MECKLENBURG COUNTY
Land Use & Environmental Services Agency

MEMORANDUM

To: Charlotte-Mecklenburg Planning Commission
From: LUESA, Mecklenburg County
Date: 1.26.22
Subject: Rezoning Petition Comments

2021-178: Statesville/Atondo Residential Development

SHEET NUMBER:
RZ-1

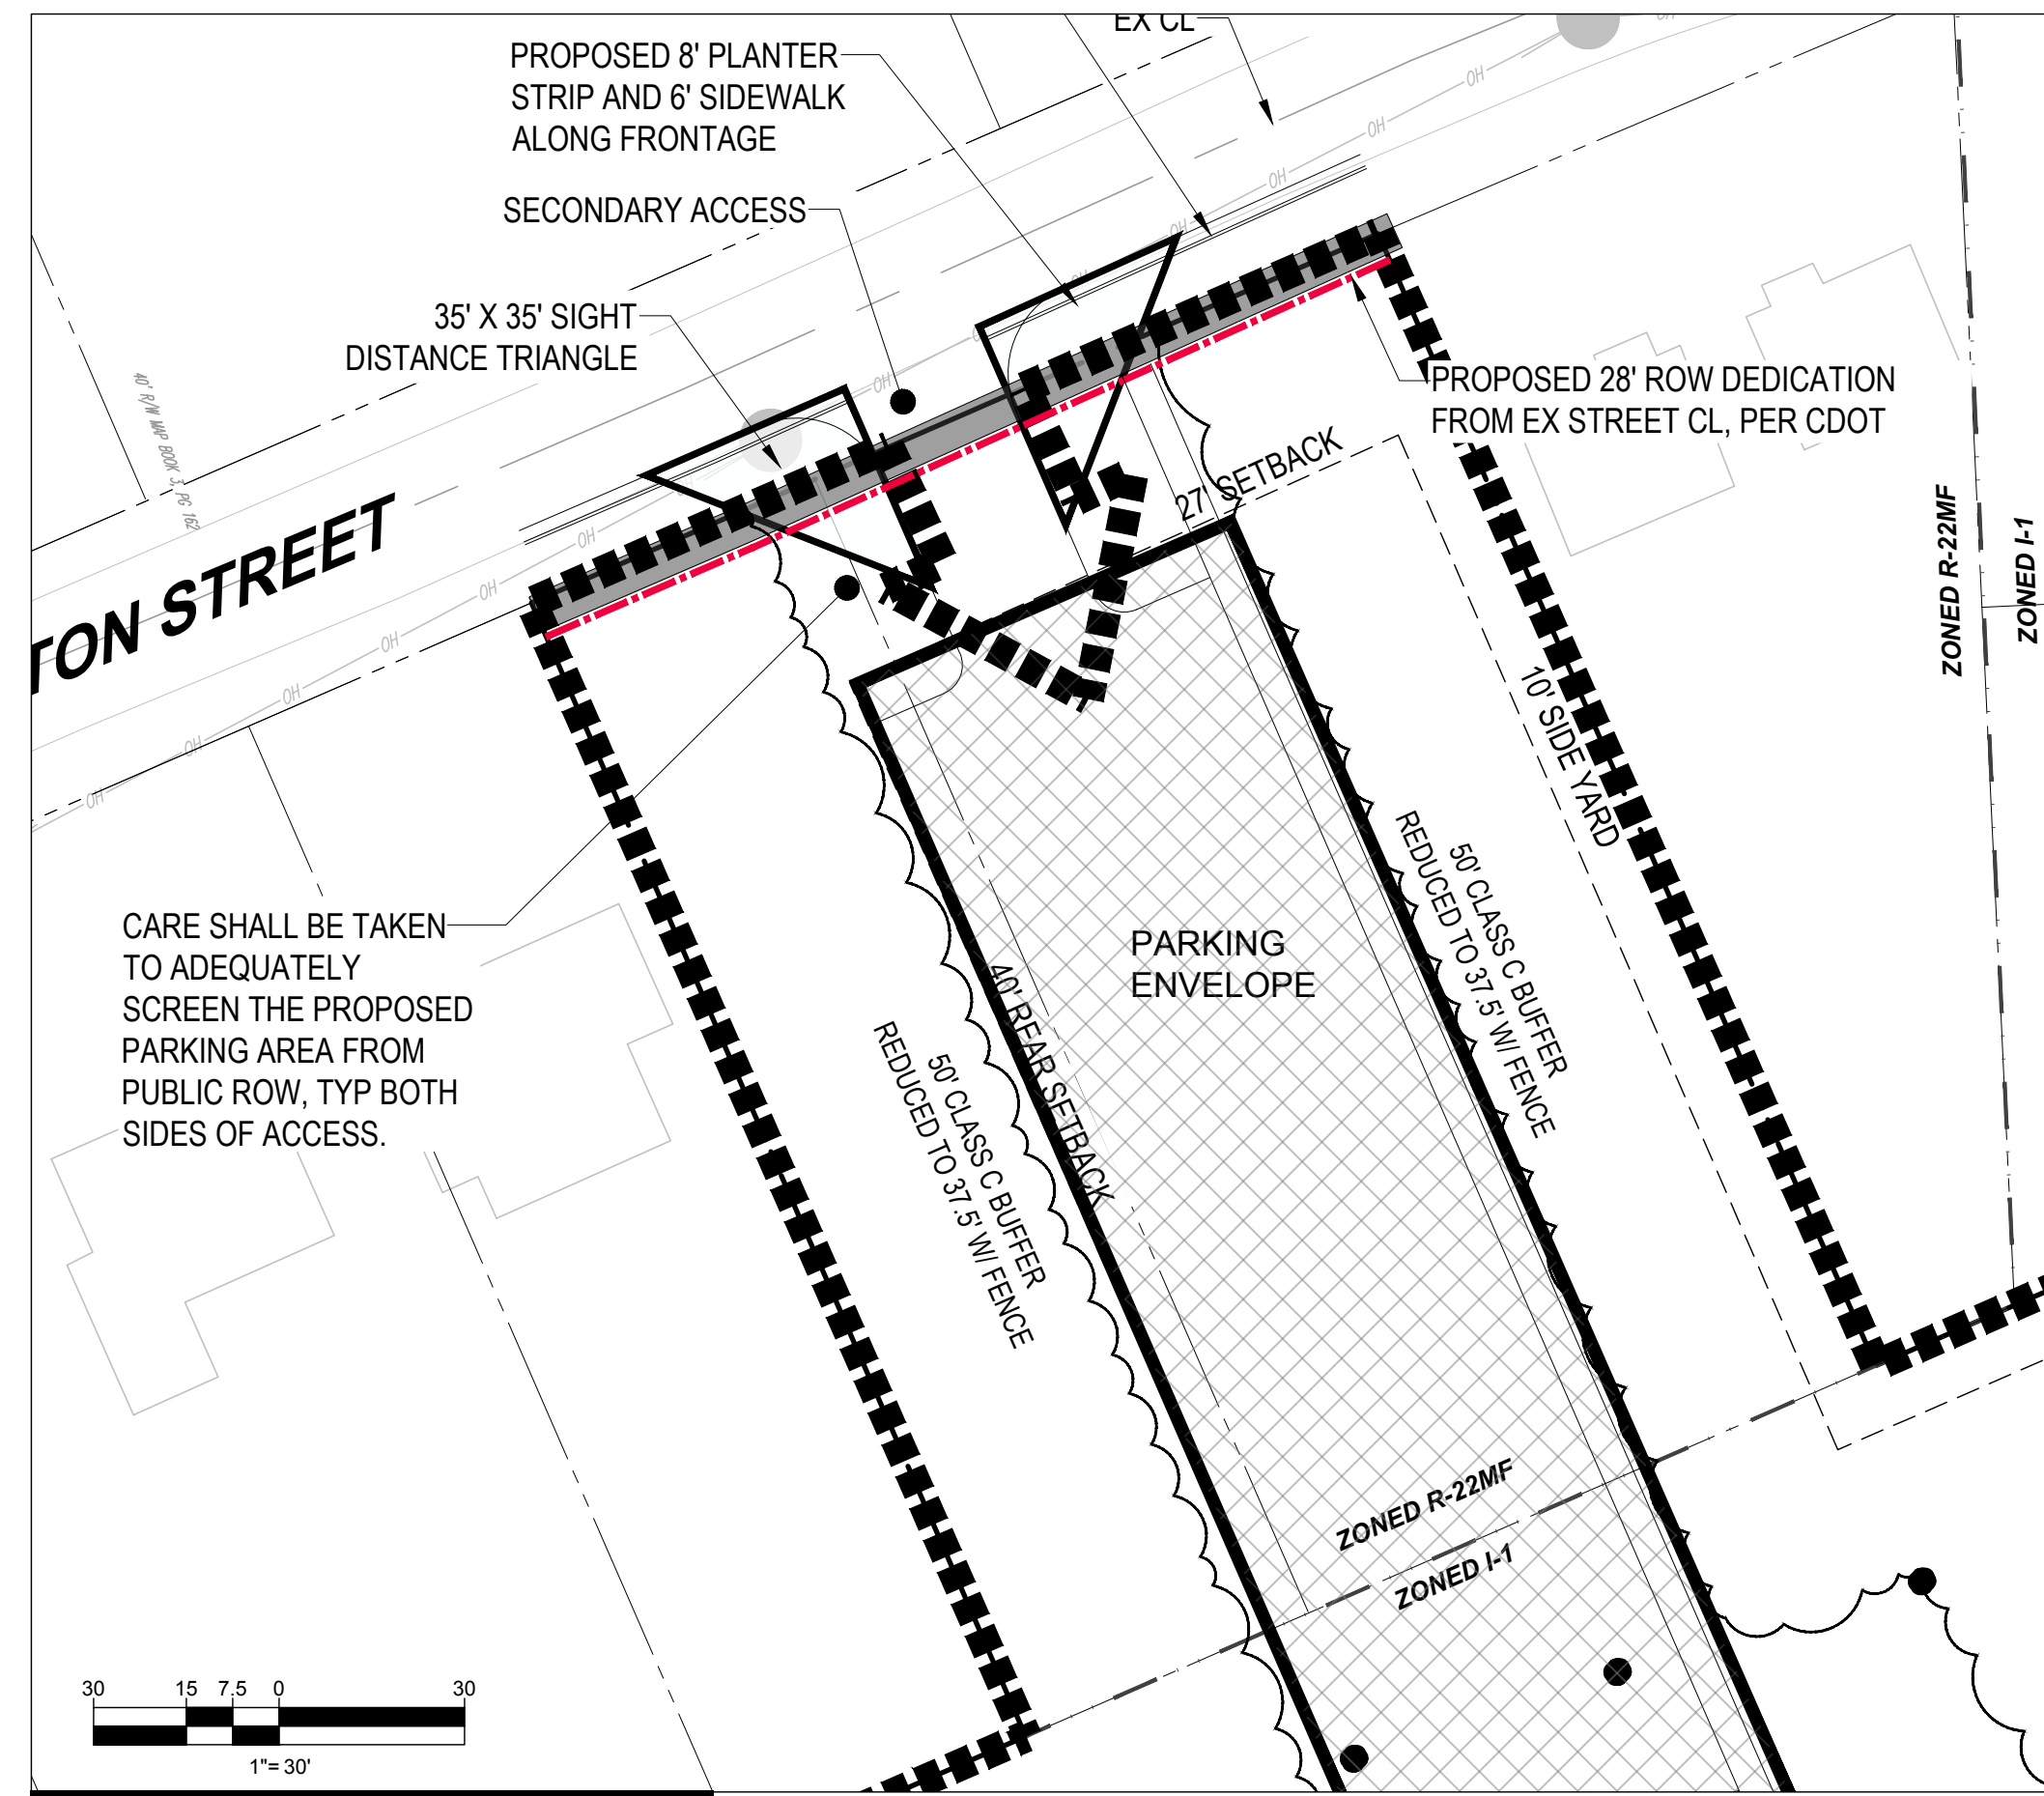
Storm Water Services Comments: A Floodplain Development permit must be obtained documenting compliance with the City of Charlotte Floodplain Regulations for all development occurring in the floodplain. In addition, staff recommend any structures proposed within the Community Special Flood Hazard Area be constructed to a Flood Protection Elevation equal to the Community Base Flood Elevation plus two (2) feet of freeboard based upon recent analyses of the future floodplains supported by the Storm Water Advisory Committee.
